**CITY OF ALBUQUERQUE**  
**Planning Department**  
**November 23, 2005**  
**DRB Comments**

**PROJECT # 1004547    APPLICATION # 05-01743**

**RE: Lower Broadway Addition**

Development Review Board 11/23/05 Agenda Item #18  
Sketch Plat: Lots 1 and 2, Block 4, Lower Broadway Addition

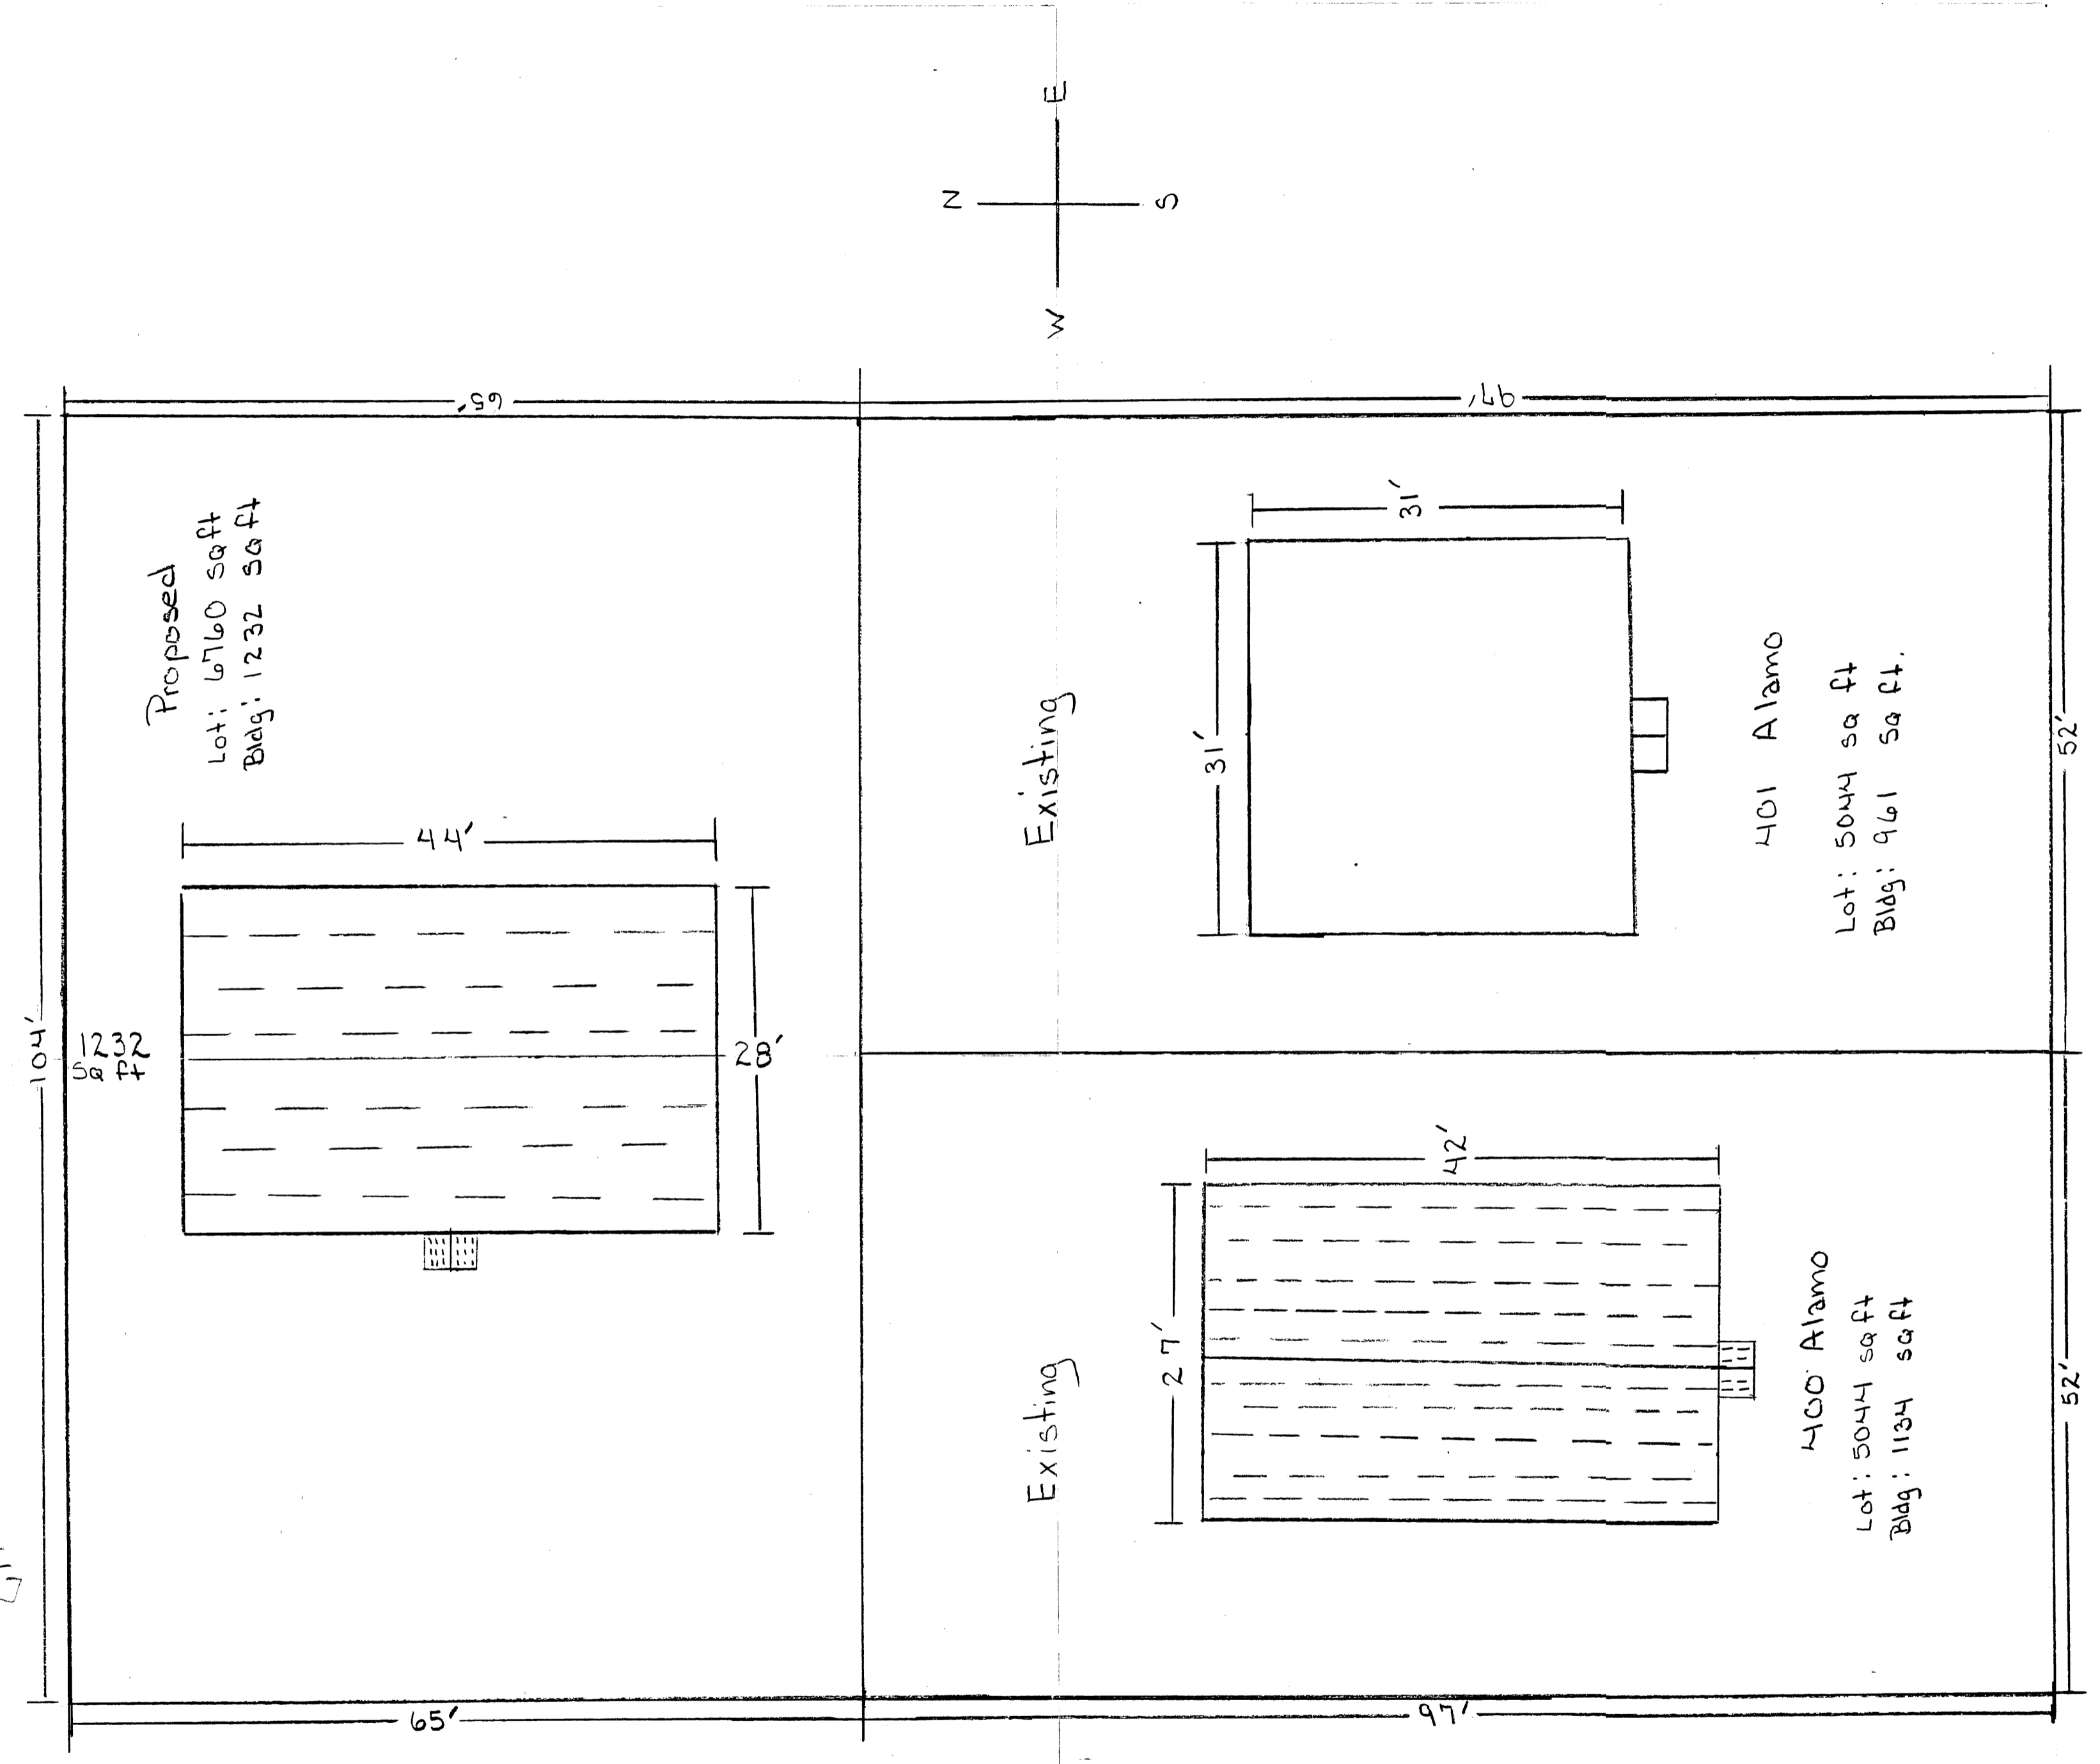
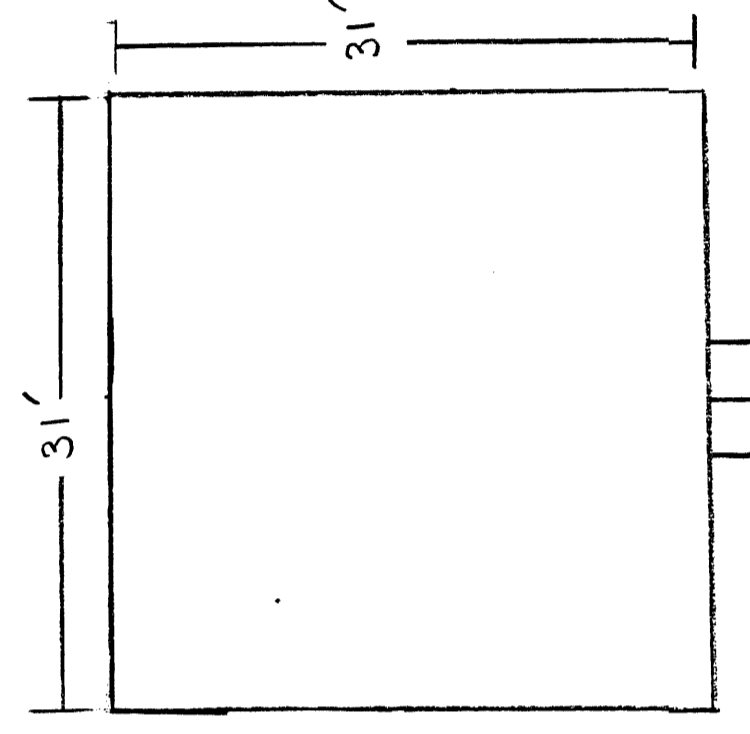
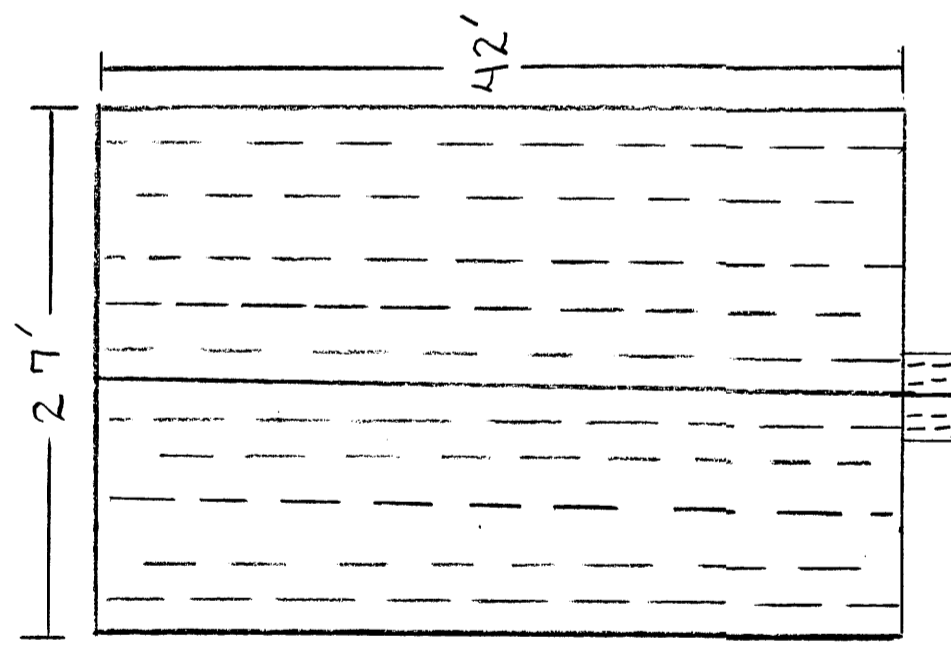
Are the existing structures on the lot facing Mechem going to be removed?
